The London Resort Development Consent Order

Appendix 12.5 Consultation responses to the 2020 EIA Scoping request

Document reference: 6.2.12.5
Revision: 00

Appendix 12.5 Consultation Responses to the 2020 EIA Scoping Report (Relevant to Terrestrial and Freshwater Ecology)

drawing title
Figure 12.4: Extended Phase 1 Habitat Survey

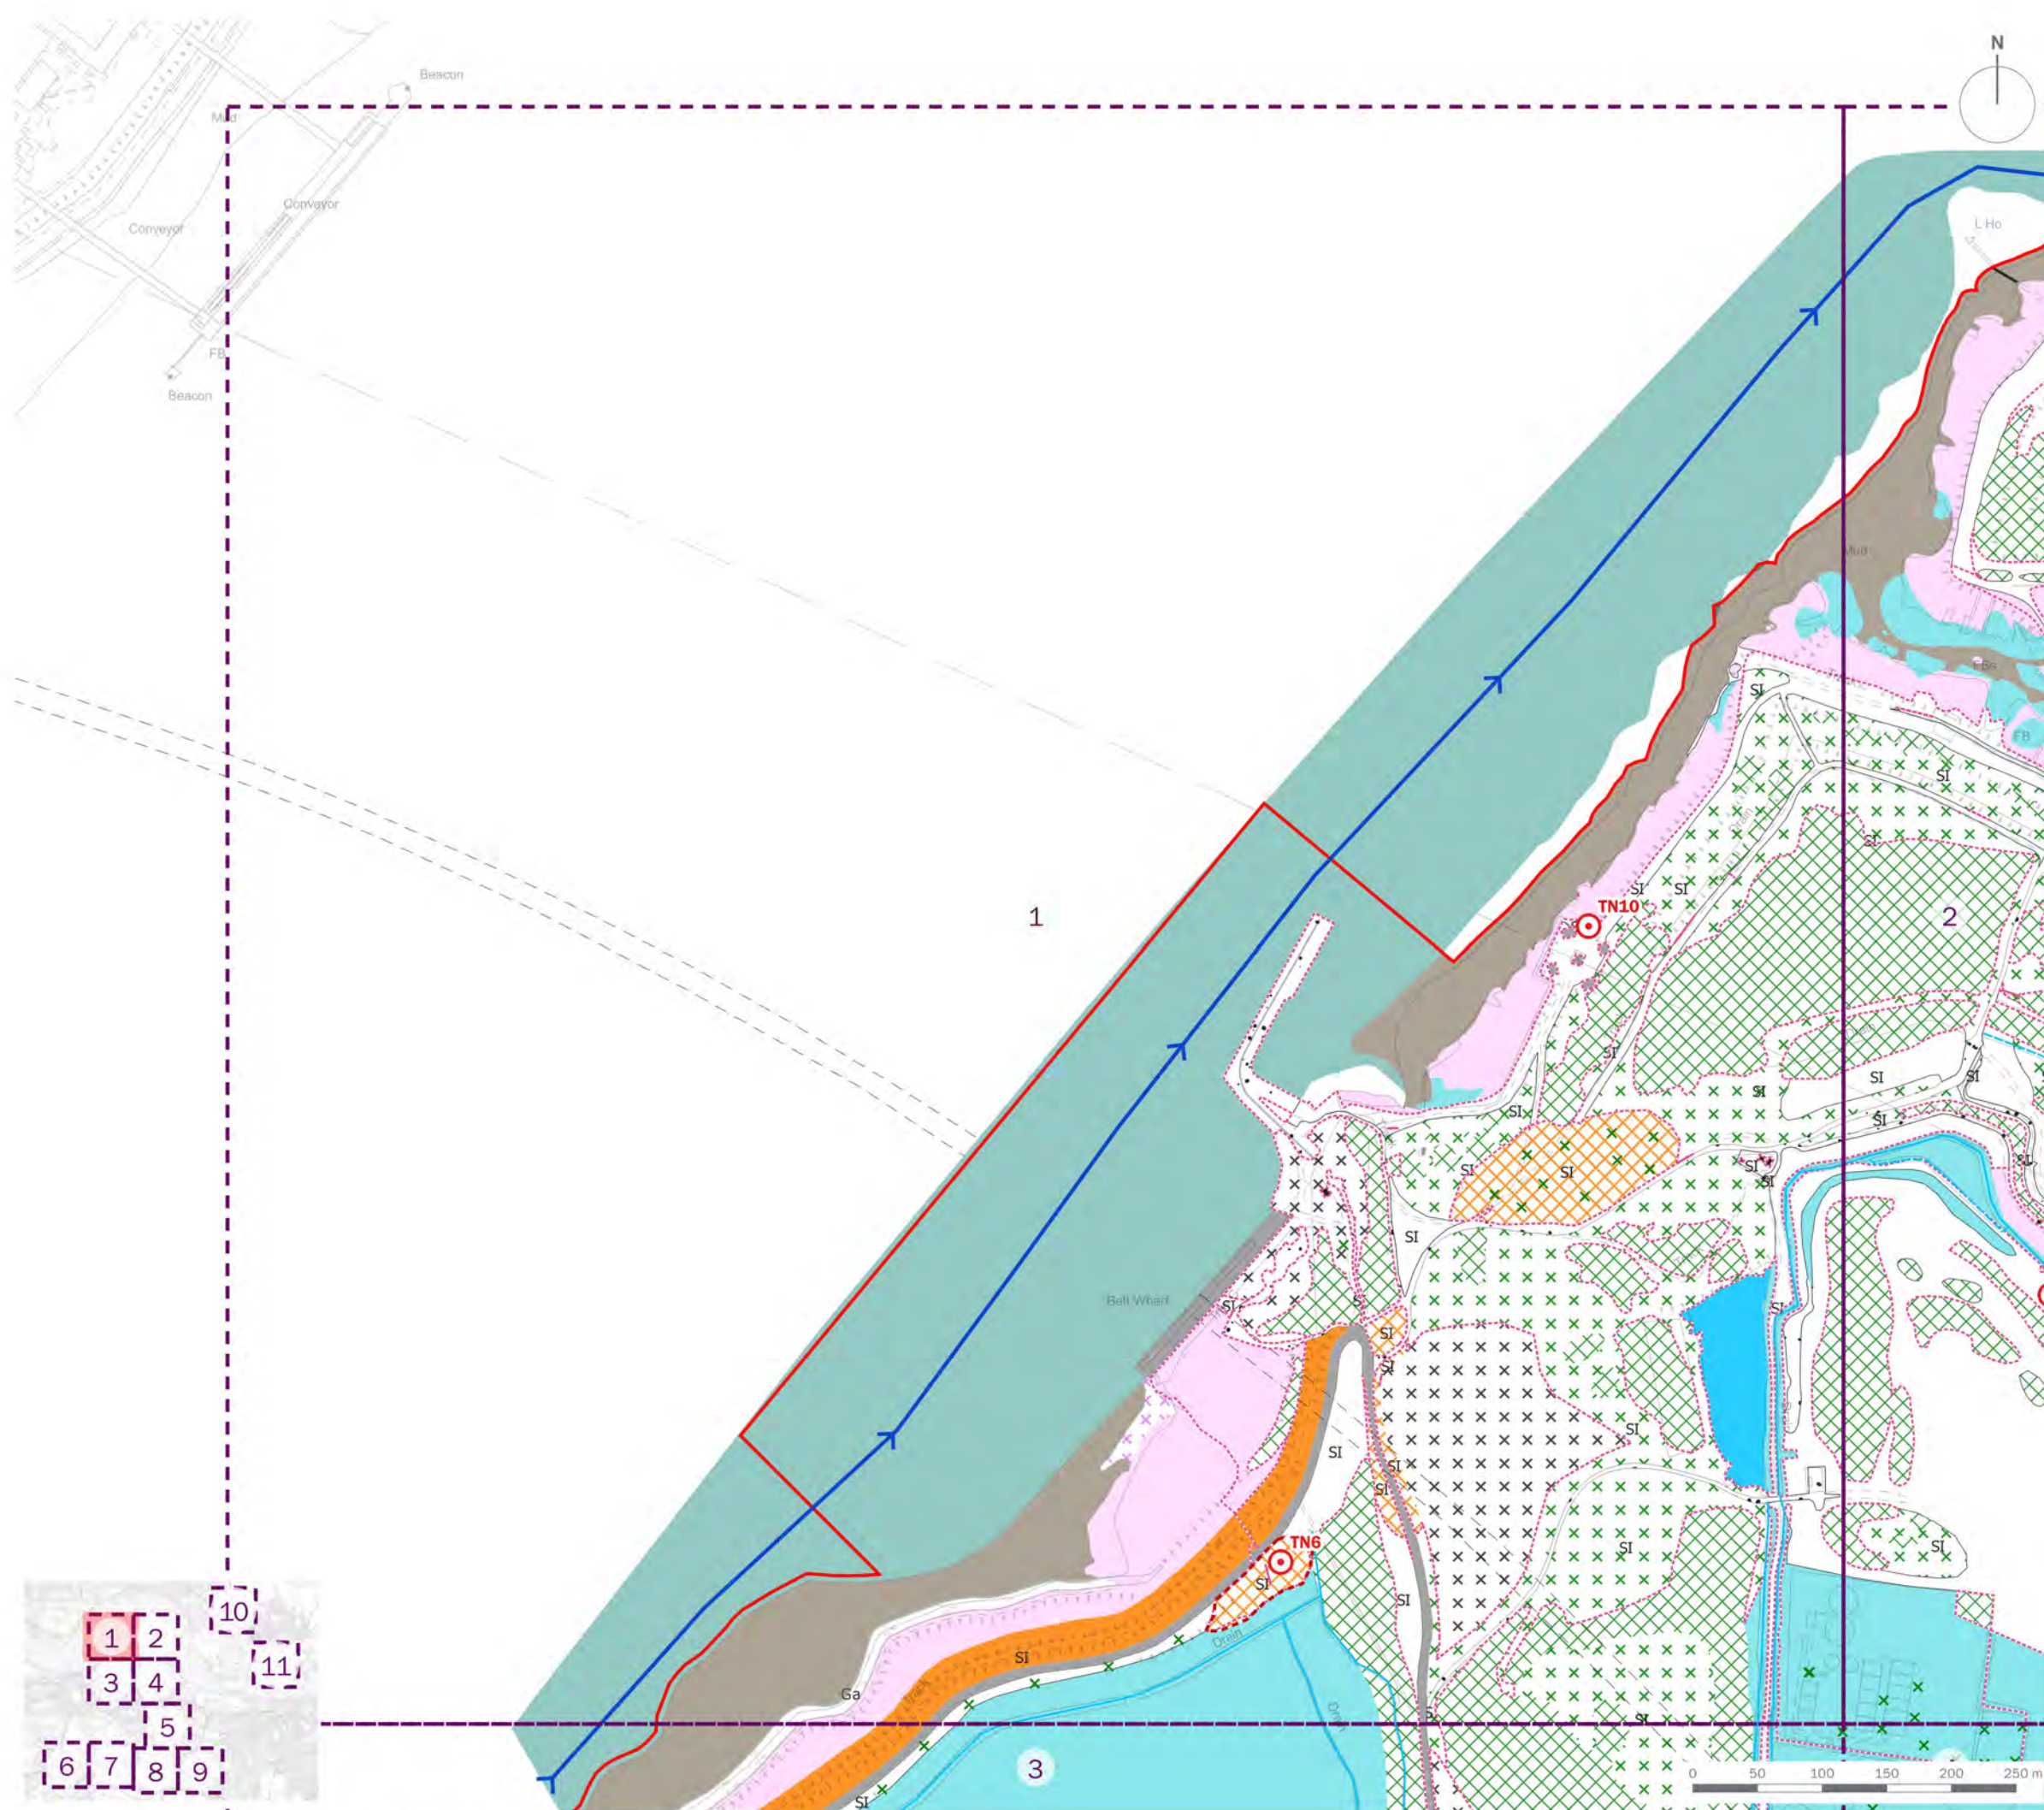
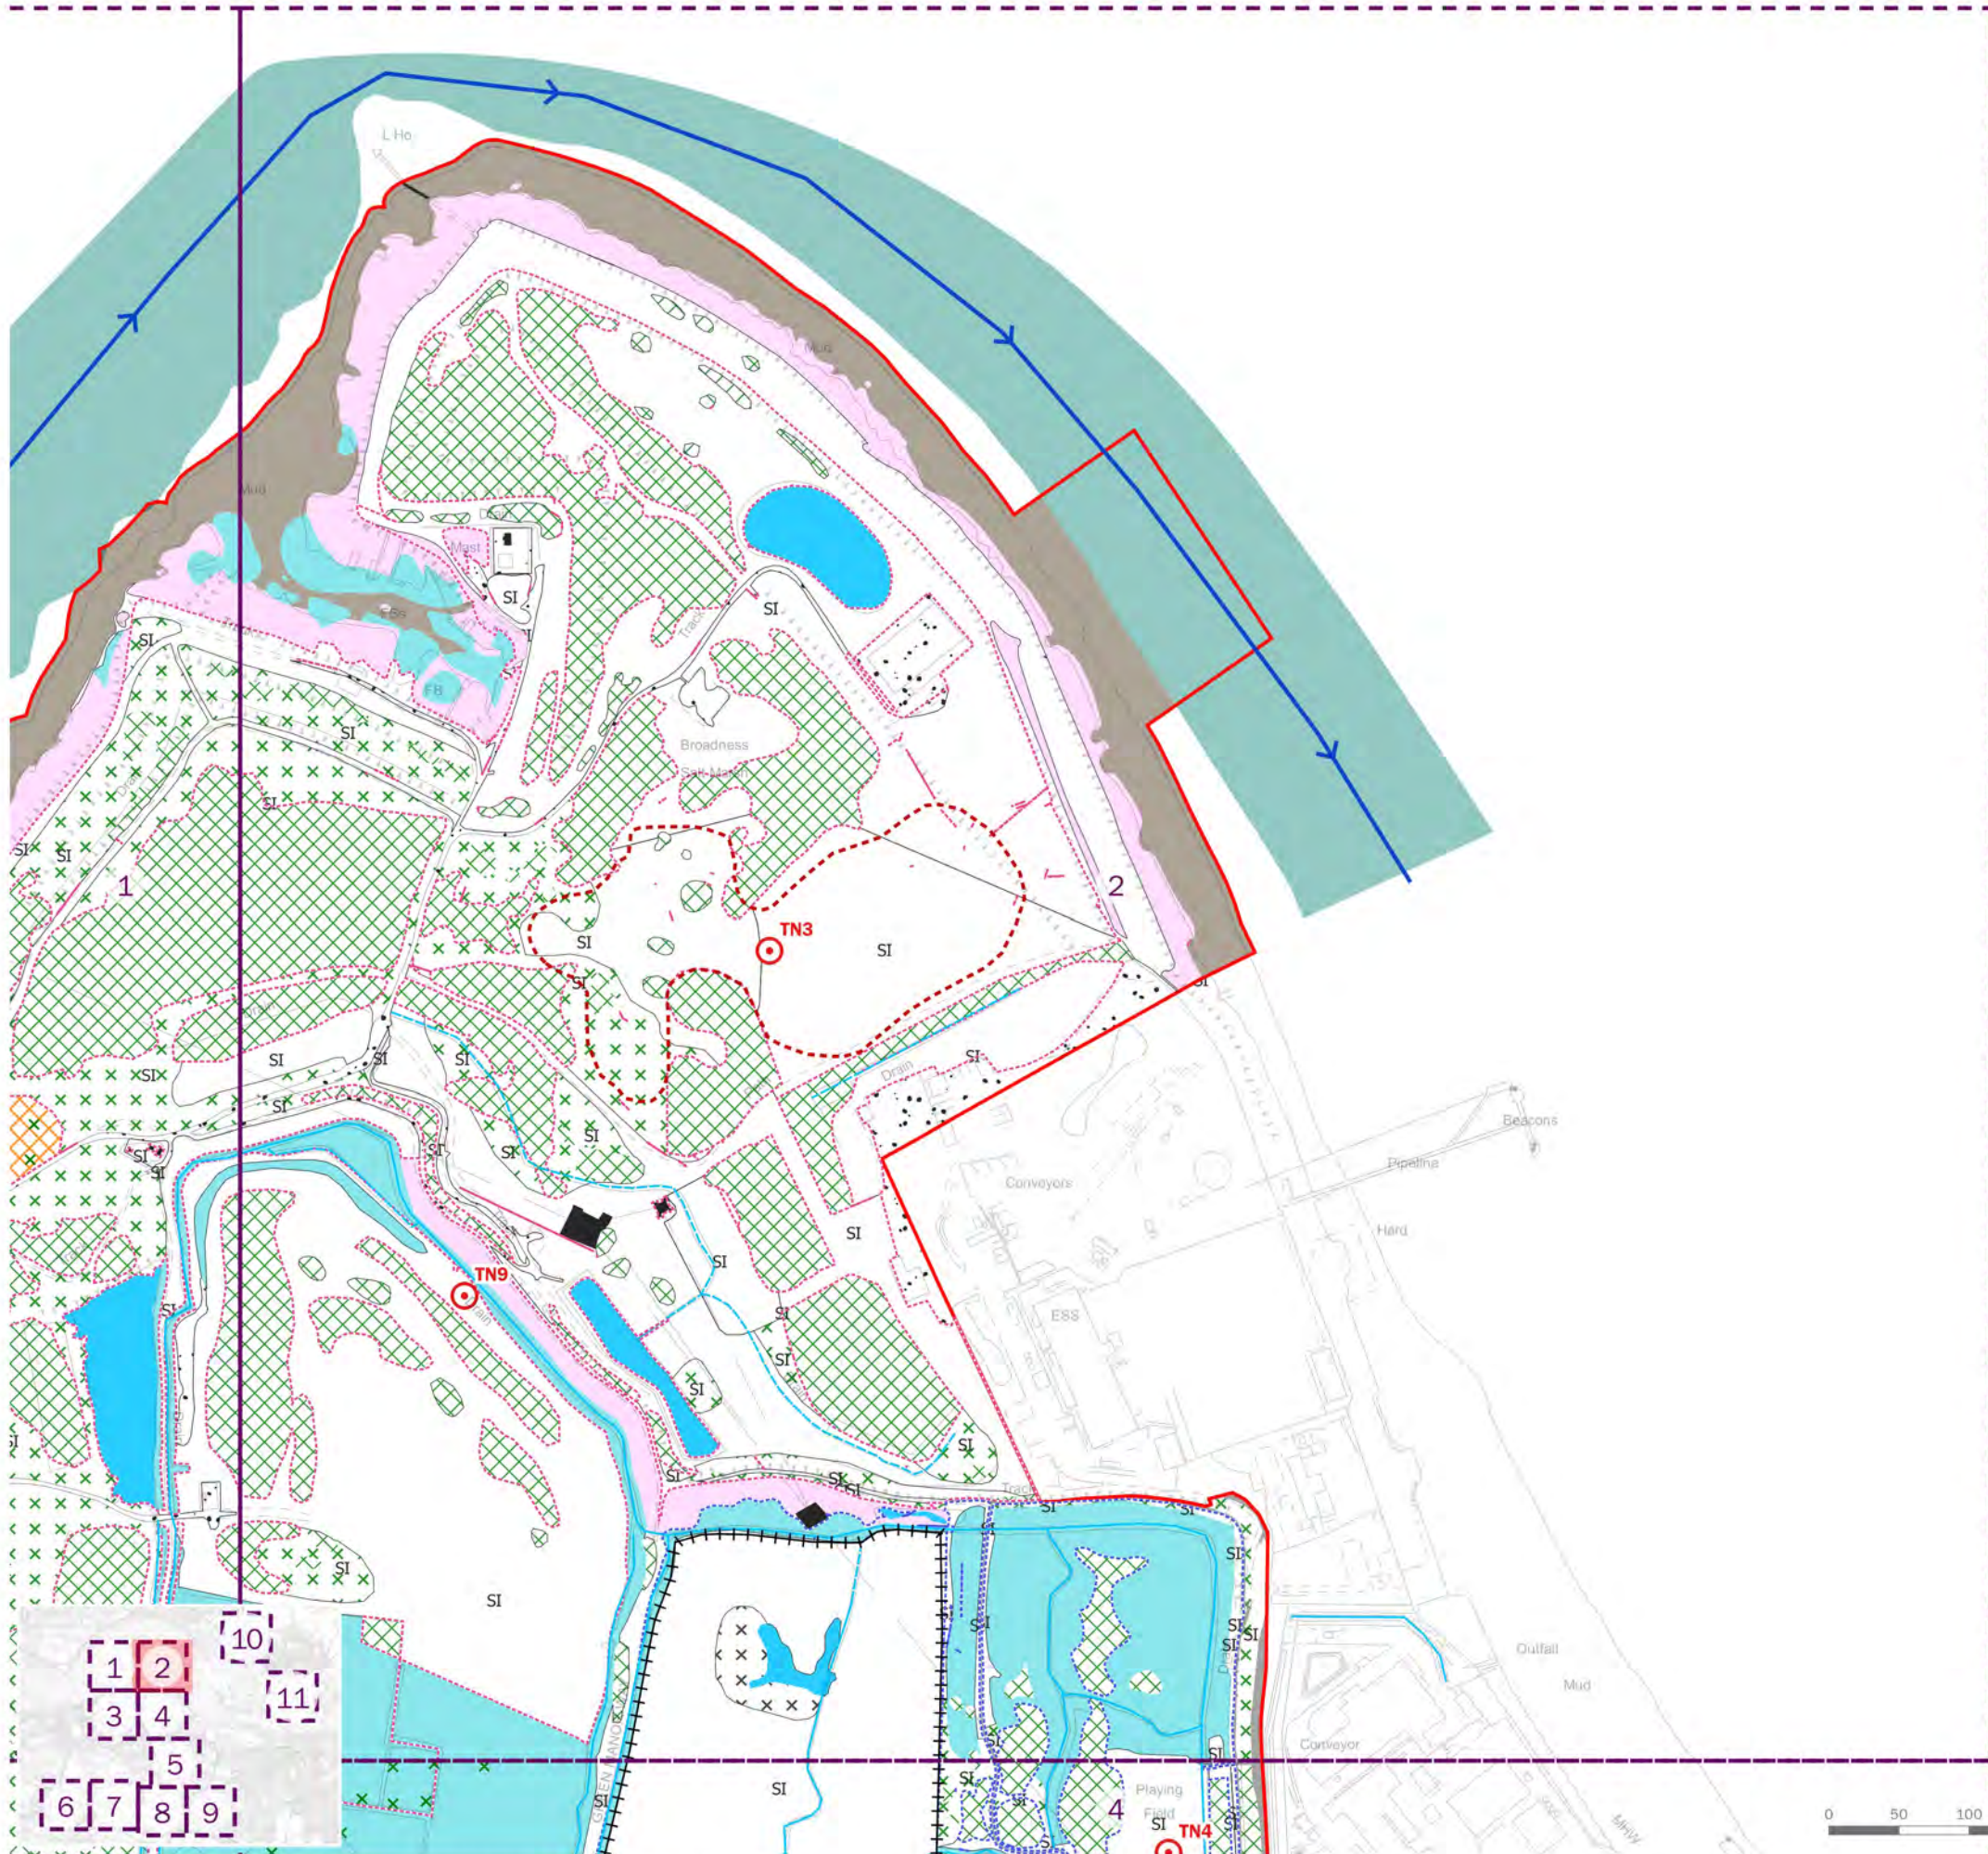
Phase 1 Habitat Plan		Drawing number edp5988_d047 lists the Thames as standing water. It is not and that reference will significantly affect how the Thames is assessed particularly for navigation. Mud will also extend beyond the low tide level.	The Phase 1 Habitat Plan has been updated to show the River Thames as moving water (tidal), with direction of flow indicated. It is acknowledged that mud extends beyond the low tide level, but for the purposes of the Phase 1 Habitat plan, the extent of intertidal mud running to the low tide level is considered sufficient.
	WFD within ES		Reference to the Water Framework Directive (WFD) is spread across three different chapters of the Scoping Report and it is not well cross-referenced which makes it confusing to follow. The terrestrial and freshwater ecology chapter of the ES is one place where the WFD is mentioned.	References to the WFD have been reviewed as part of updating the Environmental Statement ready for submission
